**RE: Legacy Church – Green Mountain Falls CDOT and El Paso County Comments**

Thank you for the comments on December 4<sup>th</sup> and 28<sup>th</sup>, 2019 for the above-mentioned project. In an effort to address your comments concisely and simplify your review process, we have summarized your comments and our responses below.

GRADING PLAN
SHEET 5 OF 14

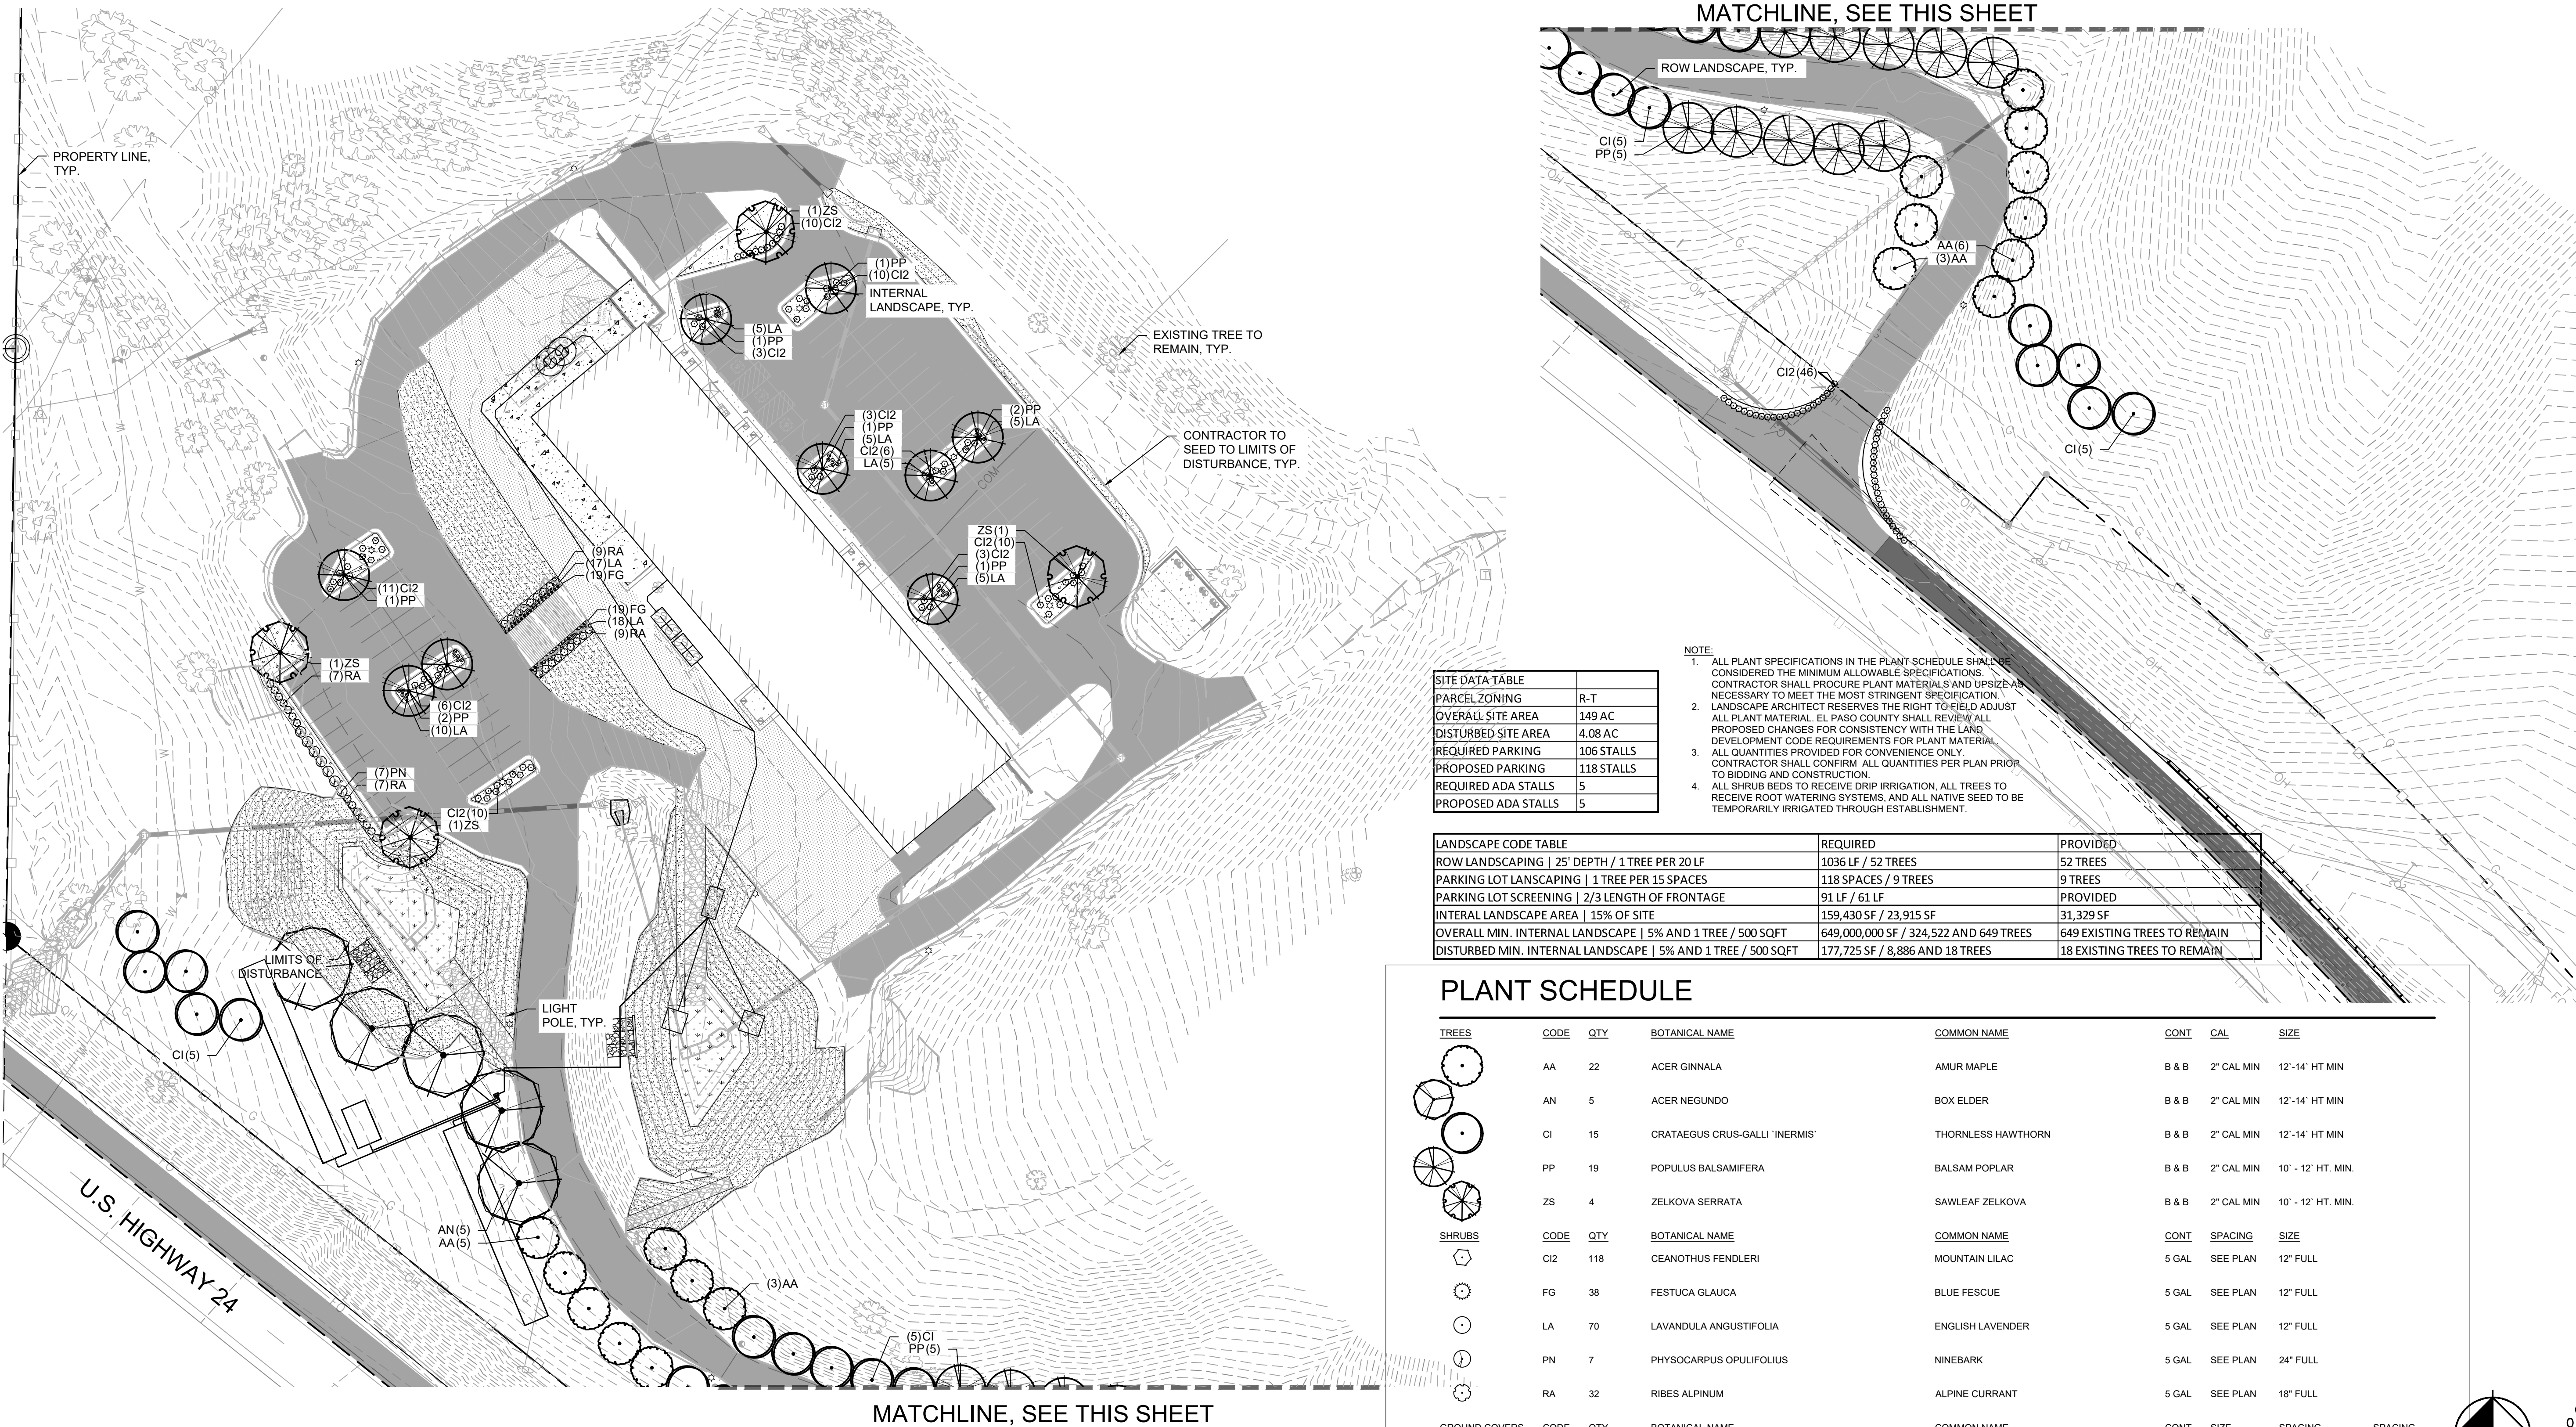
6. The % slope text is difficult to read. Please relocate or fix the hatch so that the text is readable.

8. Please fix the contour lines. It appears that there are conflicting/overlapping lines.

*Response: Wipeouts have been added behind the corresponding slope text callouts.*

*Response: Base linework has been removed so the contours accurately reflect the grading.*

EAST POND EMERGENCY SPILLWAY DETAIL (PROFILE VIEW)
N.T.S.

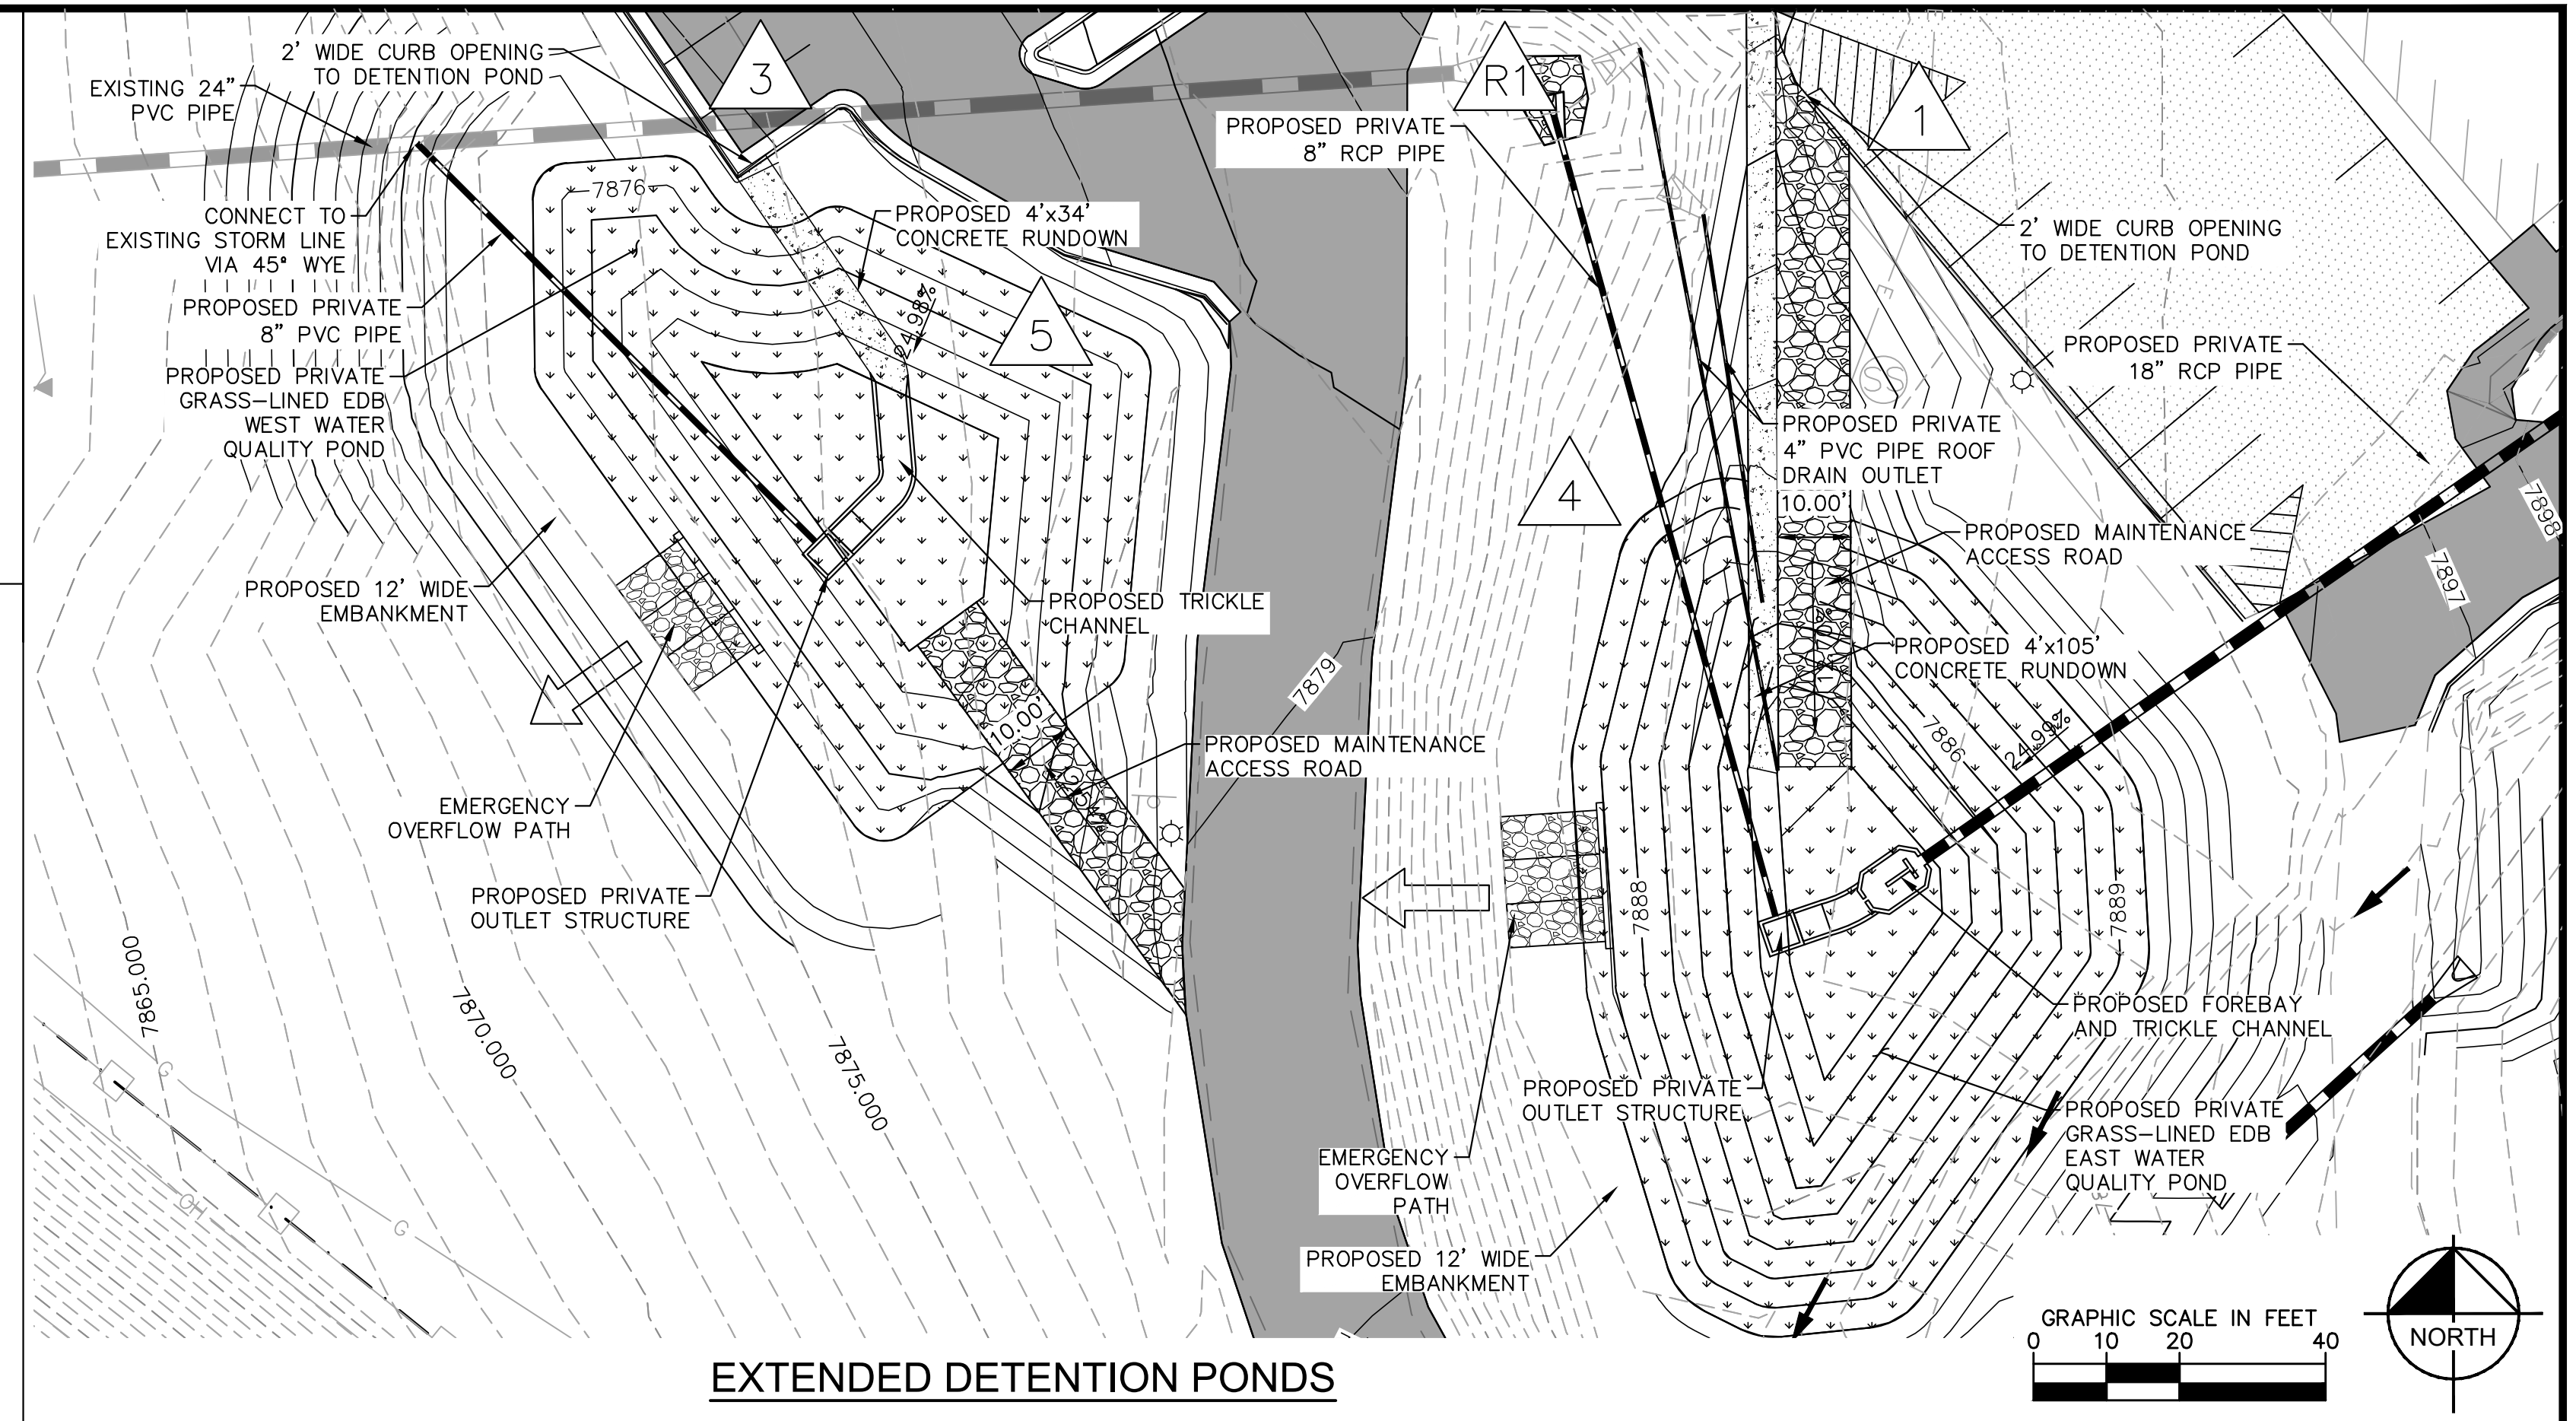
9. The pond details indicate 4 ft. Please revise so that they match (TYP.).

10. The pond detail shows the invert at 0.33" below the basin bottom. Revise so that they match (TYP.).

*Response: Weir sides have been updated to reflect 4'.*

*Response: Invert has been updated.*
